Development Facilitation Team (DFT) – Review Comments

Project No: PR-2022-006794

Location: 4801 SAN MATEO NE and LUMBER AVE NE AND MCLEOD RD NE

Application For: SD-2023-00224-VACATION OF PRIVATE EASEMENT (DHO)

<b>ALBUQUERQUE SELF STORAGE</b> 7401 San Mateo Blvd	DRAWN BY B.J.F.
	<b>GRADING &amp; DRAINAGE PLAN</b>	DATE 3/10/2022
3/15/2022 RONALD R. BOHANNAN P.E. #7868		SHEET # <b>C3</b>
5571 MIDWAY PARK PLACE NE ALBUQUERQUE, NM 87109 (505) 858-3100 www.tierrawestllc.com		JOB # 2020068

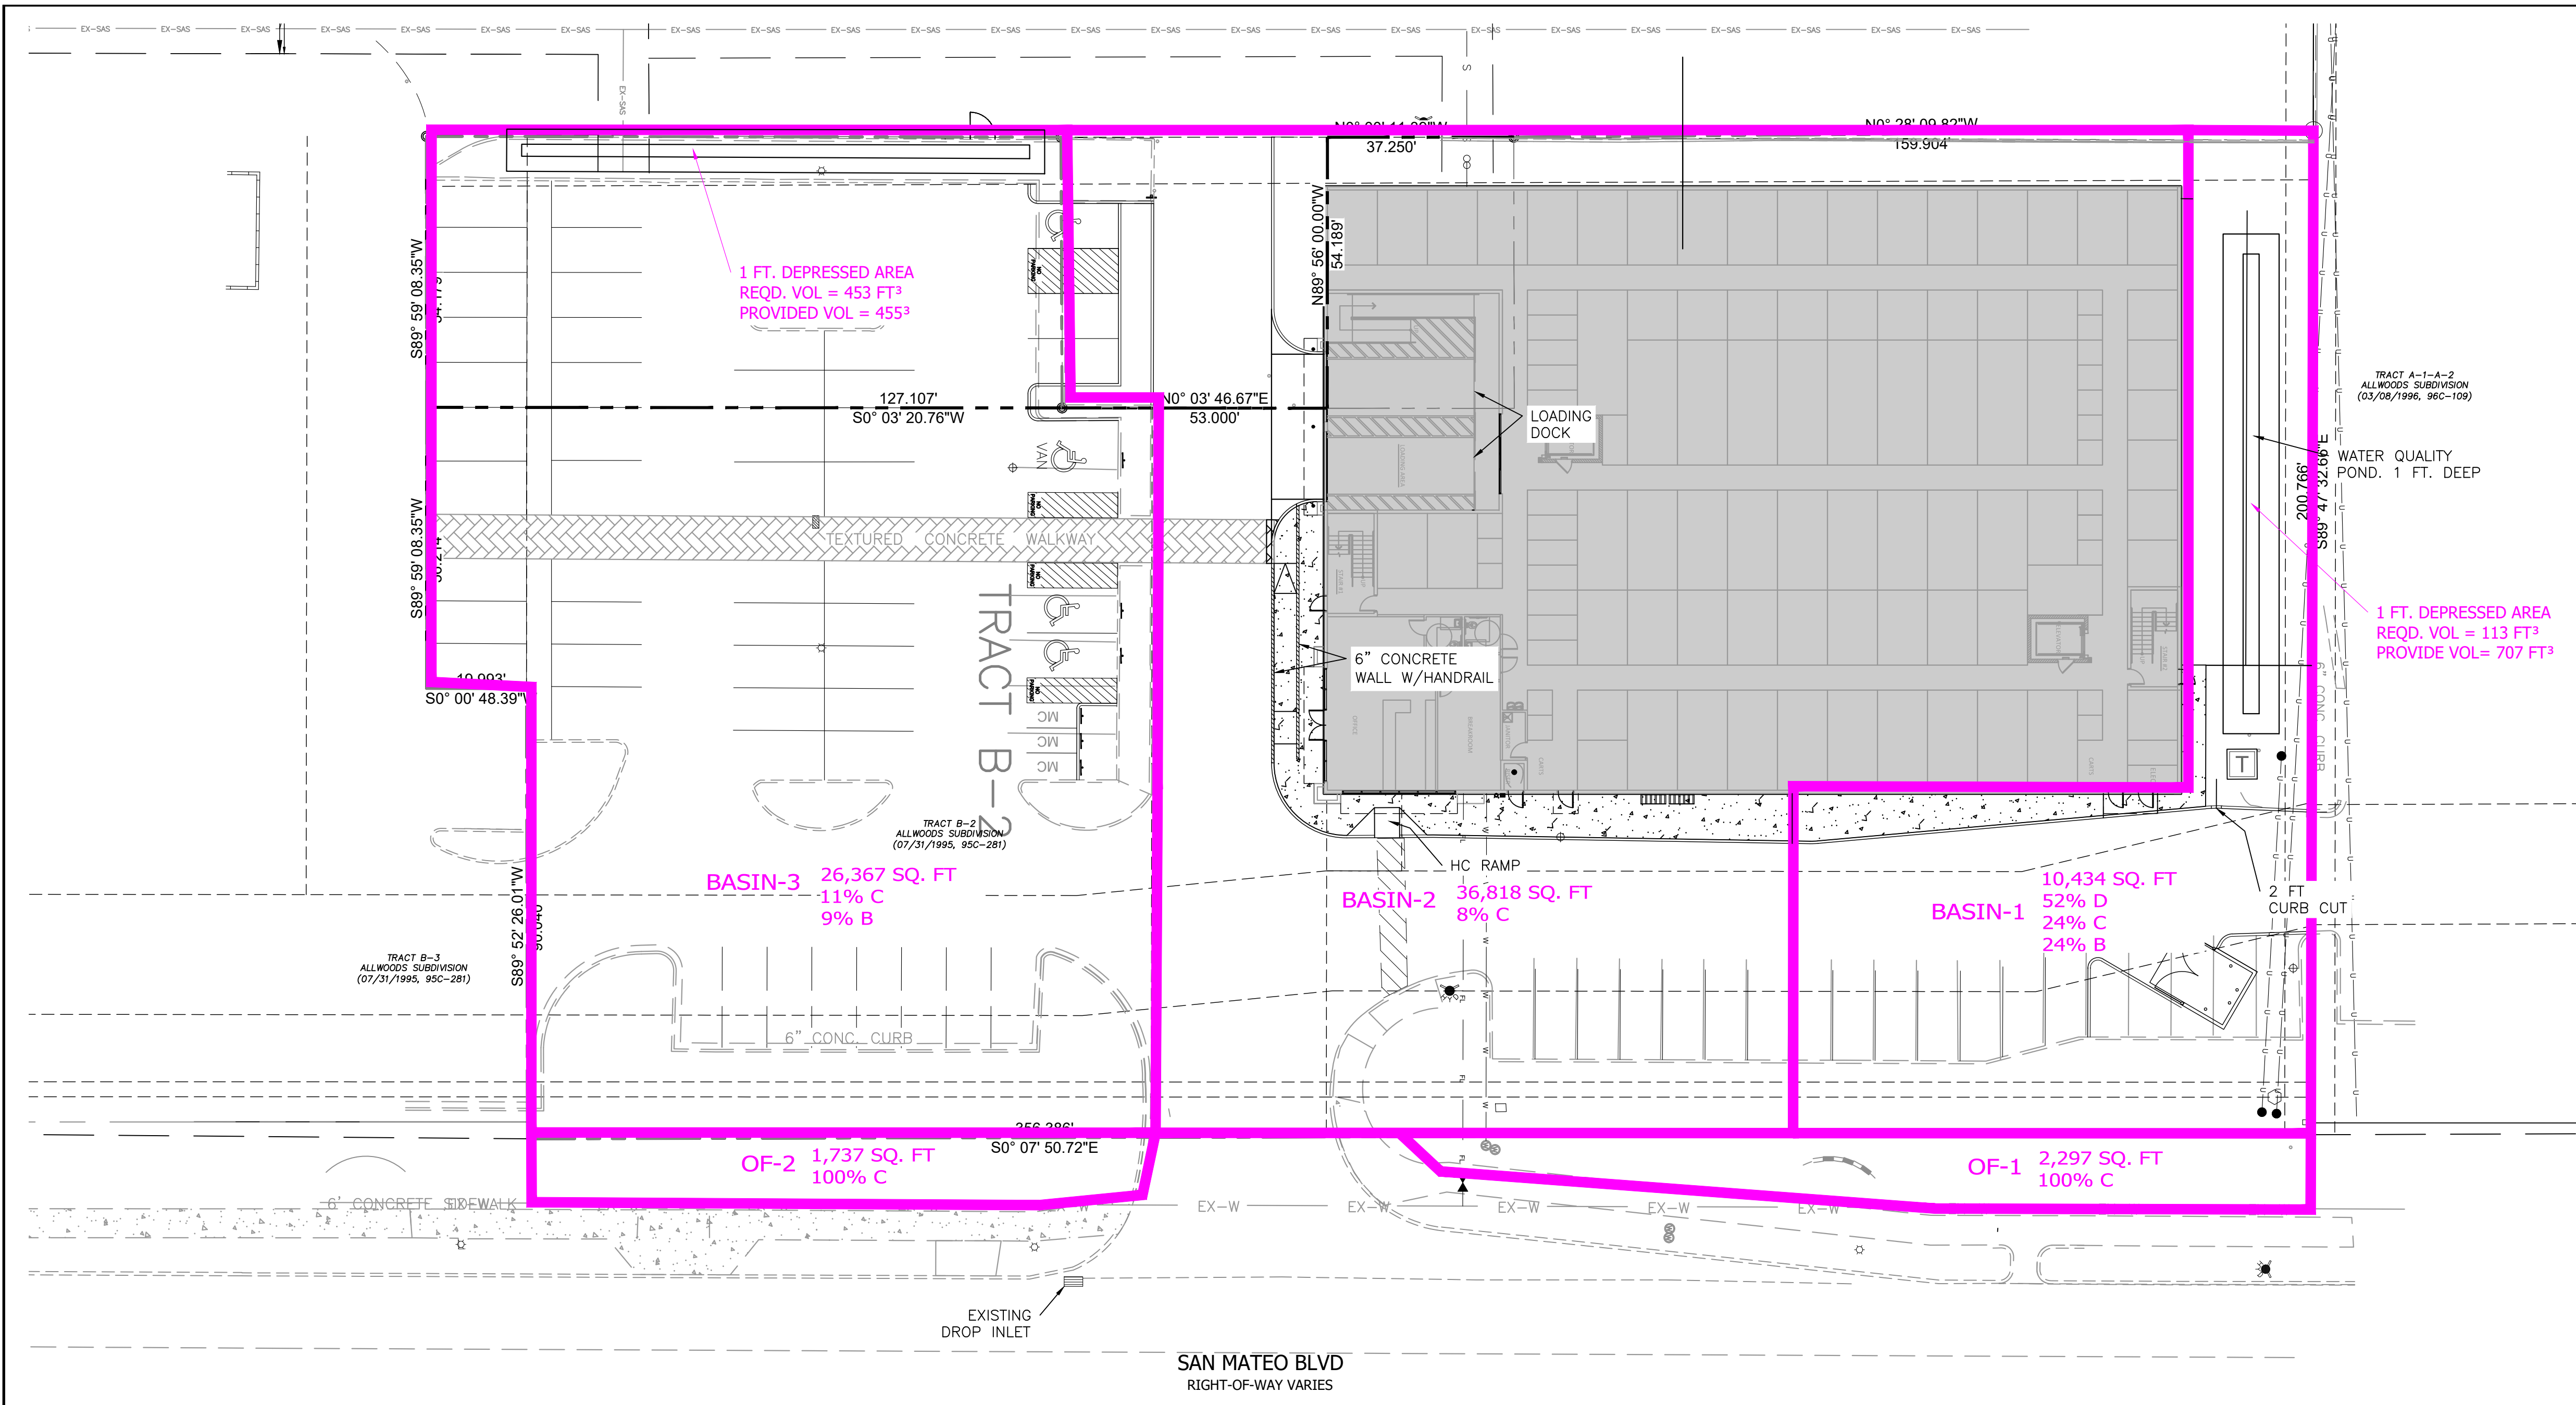
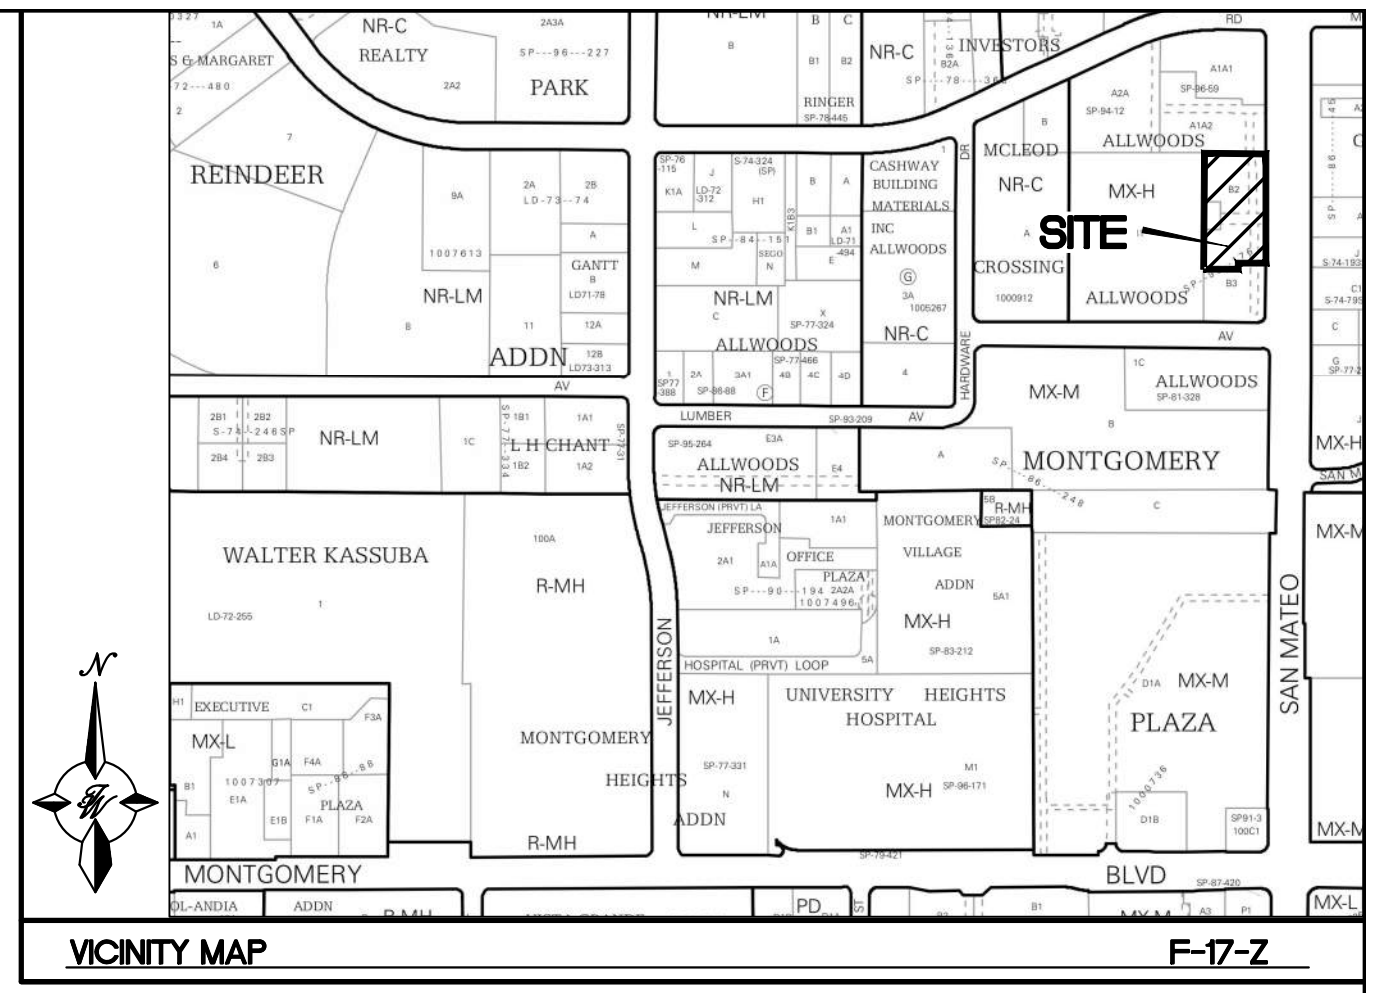
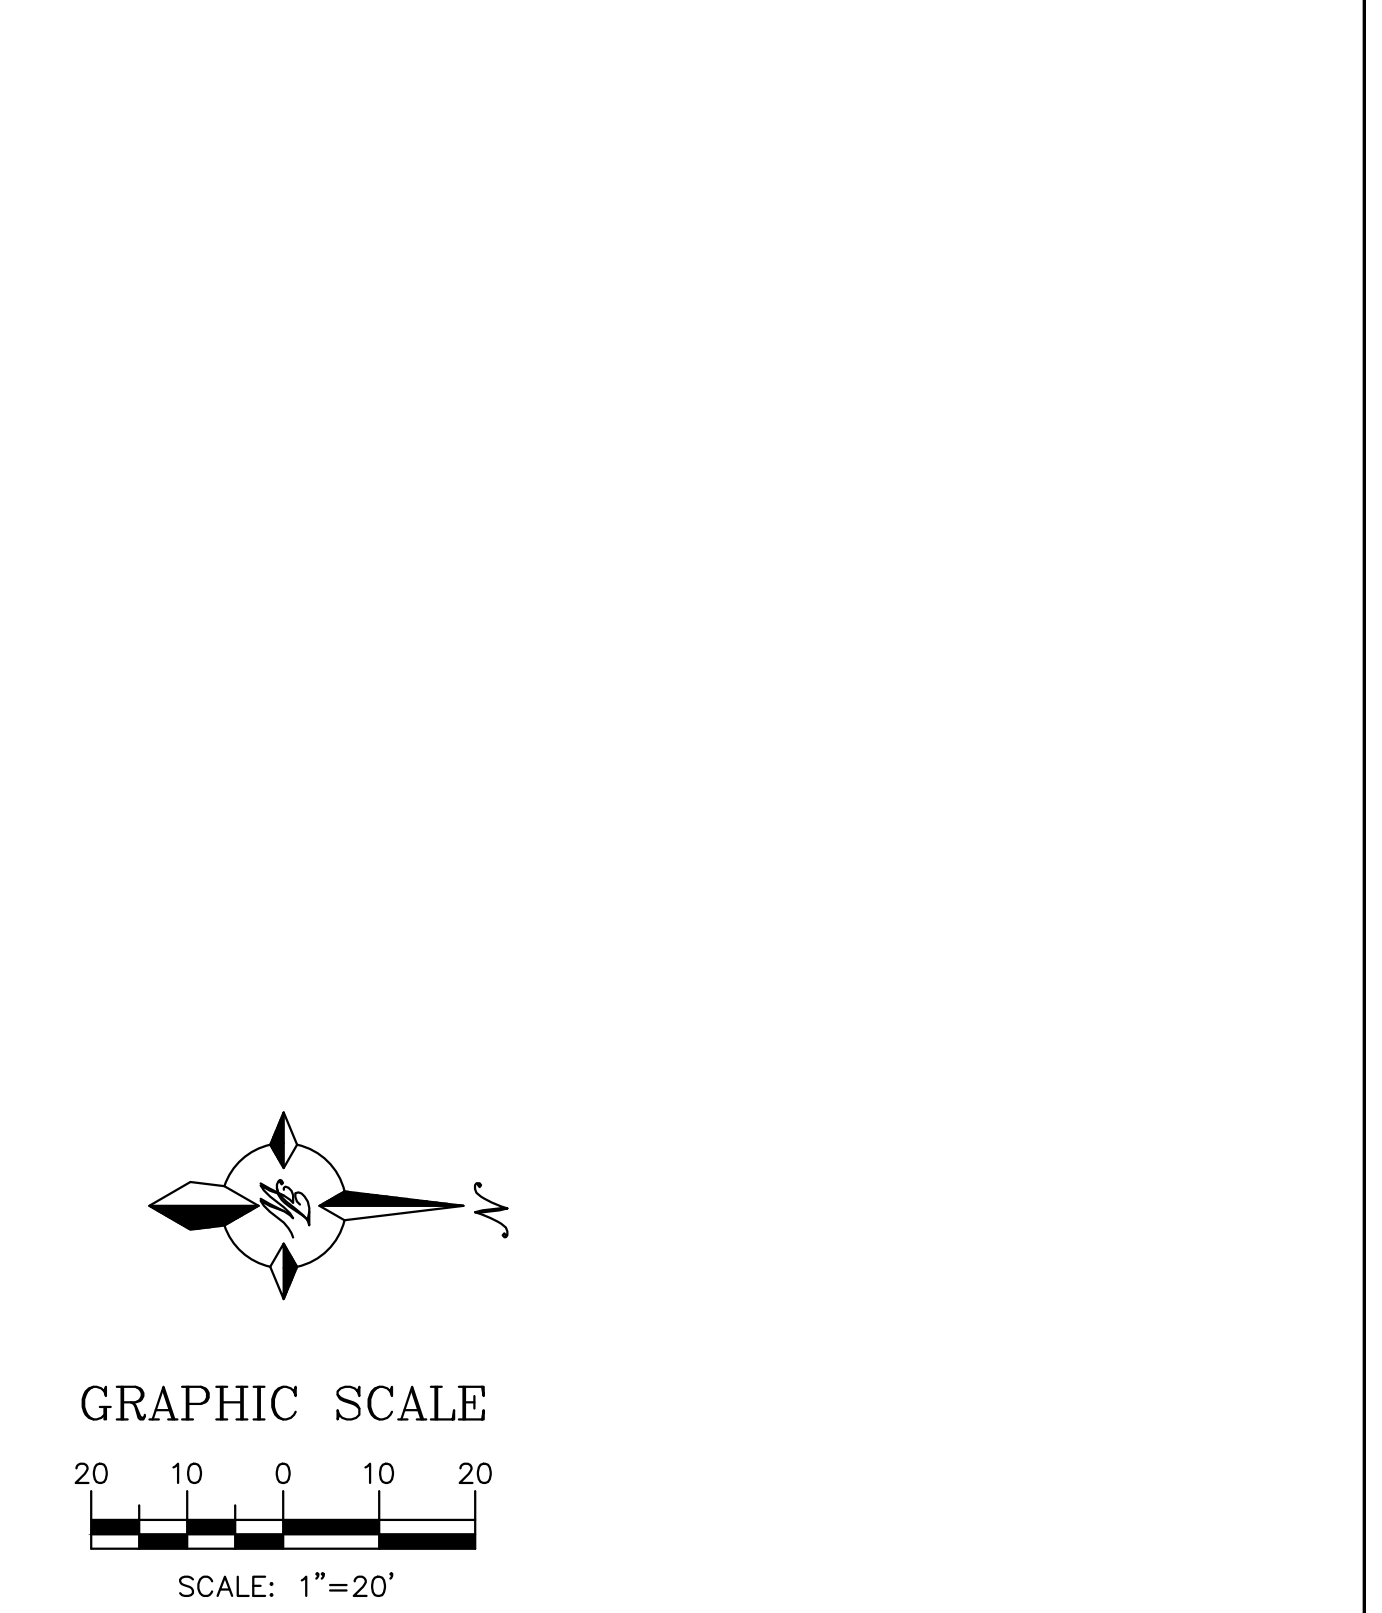
- Hydrology has an approved Conceptual Grading & Drainage Plan (F17D002K) with engineer's stamp 03/15/2022.
- Hydrology needs to have the existing structures in relationship to the plat. An aerial exhibit will do. Hydrology needs to determine where the approved Conceptual Grading & Drainage Plan is located within the plat.
- Add a Cross Lot Drainage Easement note specifying the beneficiary and maintenance agreement.
- Comment - Prior to submitting for Building Permit, a licensed New Mexico civil engineer will need to submit a Grading & Drainage Plan to Hydrology for review & approval if one of these conditions is met. (500 cy of grading, 1,000 sf of proposed building, or 10,000 sf of proposed paving).
